PHIL HEATON ASSOCIATES LIMITED

STRUCTURAL REPORT – 01 November 2021

Ref. St James CE Primary School, Greenacre Street, Clitheroe BB7 1ED

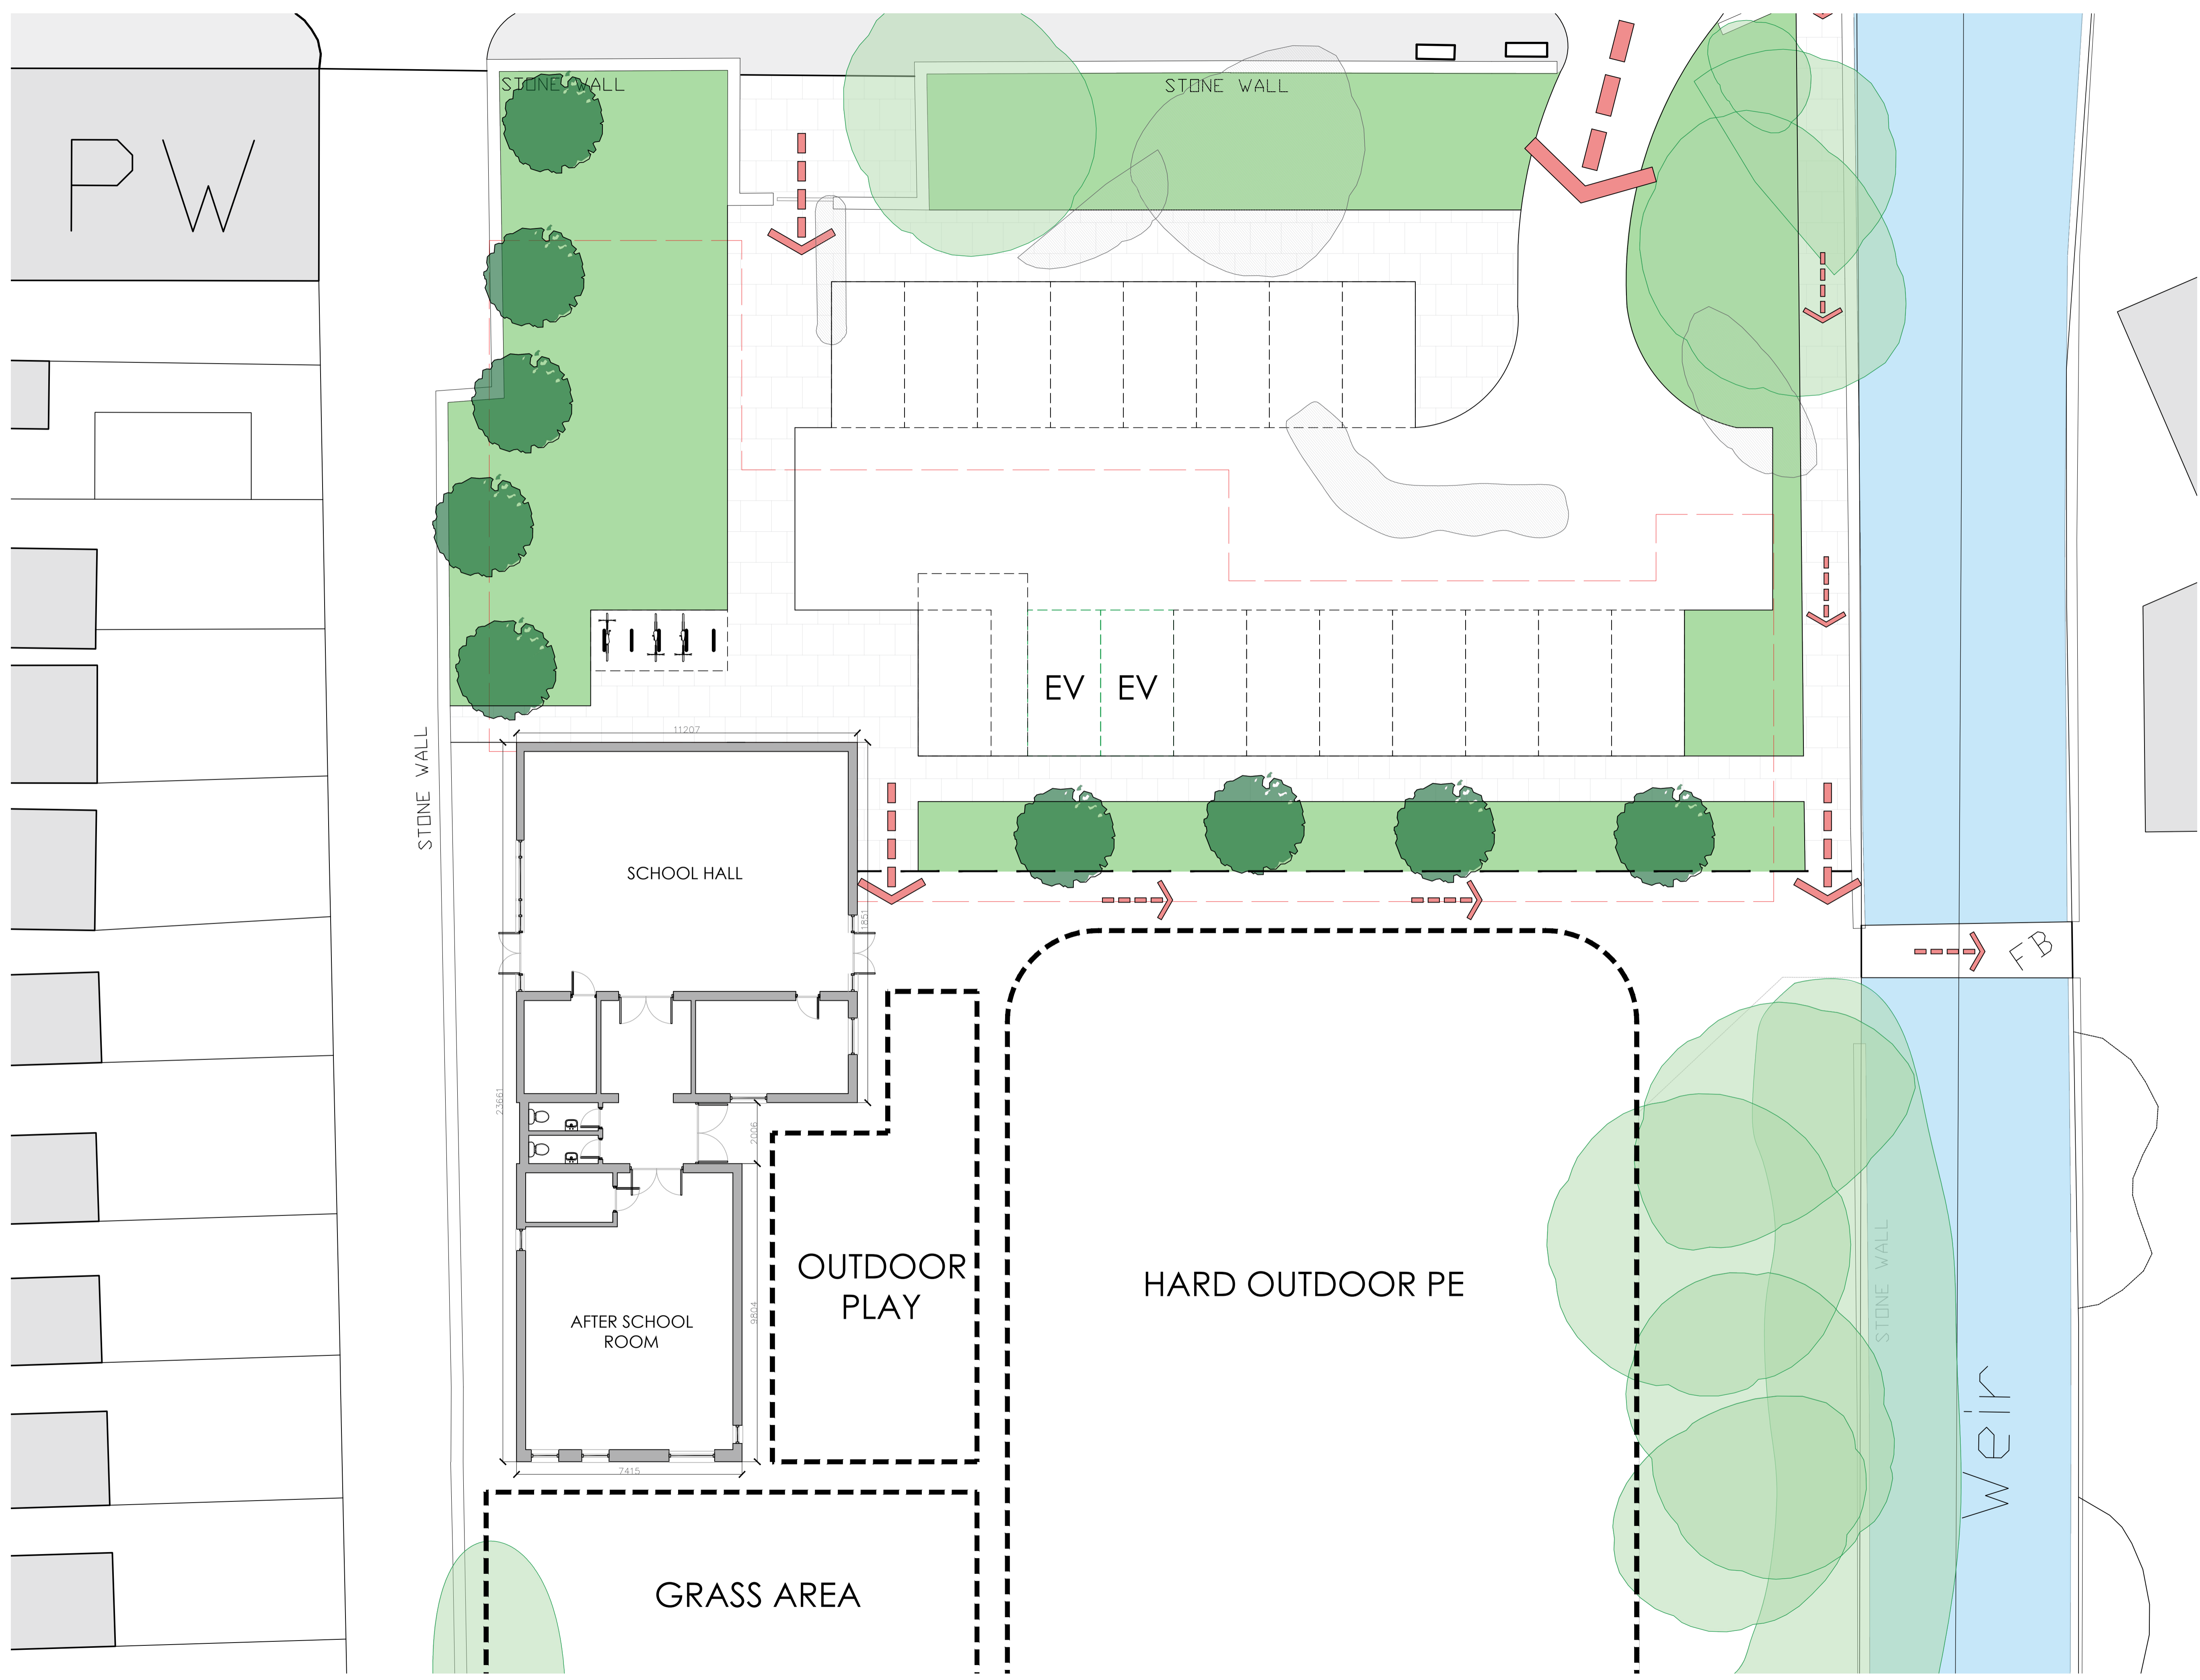
Further to our recent discussions and pursuant to my call last week with Carole Woosey at the Environment Agency (EA), the proposals at present with a raft foundation and ground bearing slab means we cannot satisfy the requirements to replace the loss in flood water storage within the site boundary. A simple calculation has proved this.

What can be achieved, however, is to utilise a full sub floor void to the building whereby the flood water capture presently available on the site is retained by raising the floor level either on exposed steel encased piles or blockwork piers and constructing a beam and block floor over the void. This will cause a consequential rise of the overall height of the building and the void will need to be guarded with a suitable means of preventing children from entering this confined space.

Either solution should also consider a minimum 30cm air gap above the highest flood water level to the underside of the floor structure to future-proof the structure and also prevent buoyancy issues arising.
